# CITY OF ALBUQUERQUE

**Re: Paseo del Norte Sportsplex Drainage Report**  
**Engineer's Stamp dated 12-29-04**

Based upon the information provided in your submittal dated 12-29-04, the above referenced report is approved for Site Development Plan. Prior to Building Permit approval, please address the following comments.

EMERGENCY SPILLWAY DETAILS

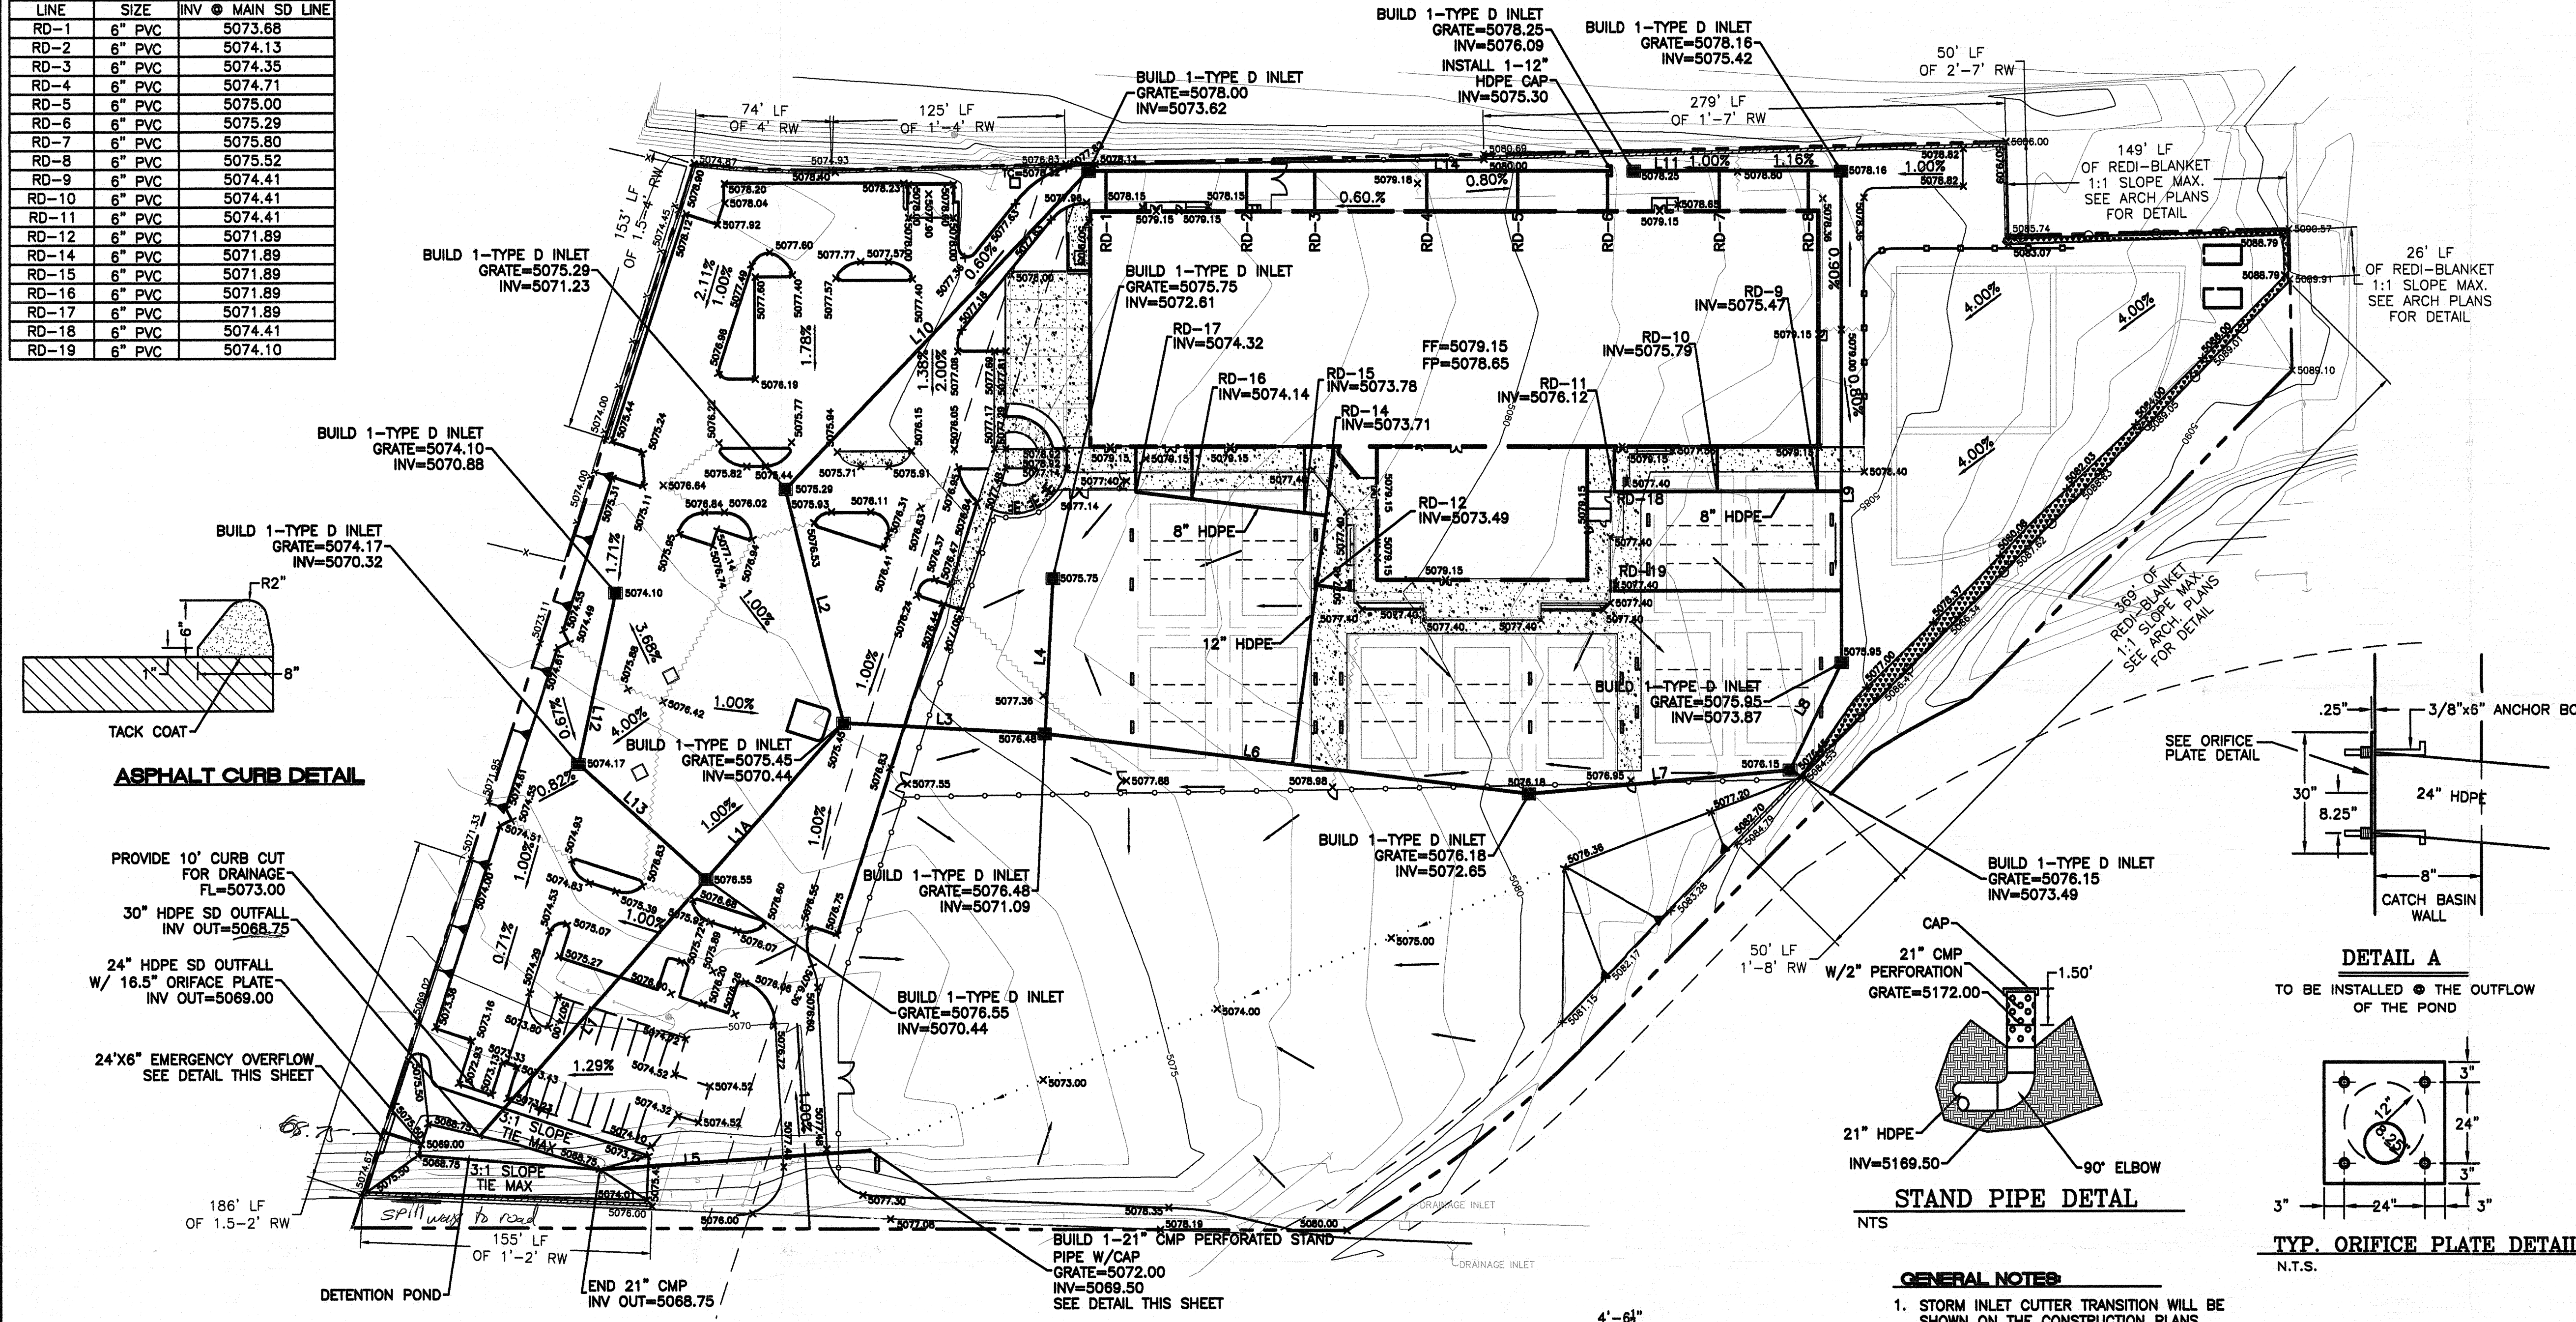
- Please direct the emergency spillway toward Paseo del Norte.
- How does the runoff leave the pond? Does it daylight to the existing grade?
- Please check the volumes of the pond – they appear small. This will probably affect the AHYMO run.
- Pipes 7 and 8 are undersized. Also, please check your weir calculation.
- Please include exhibit from the previous report (C17-D19) showing allowable discharge to the property to the west.
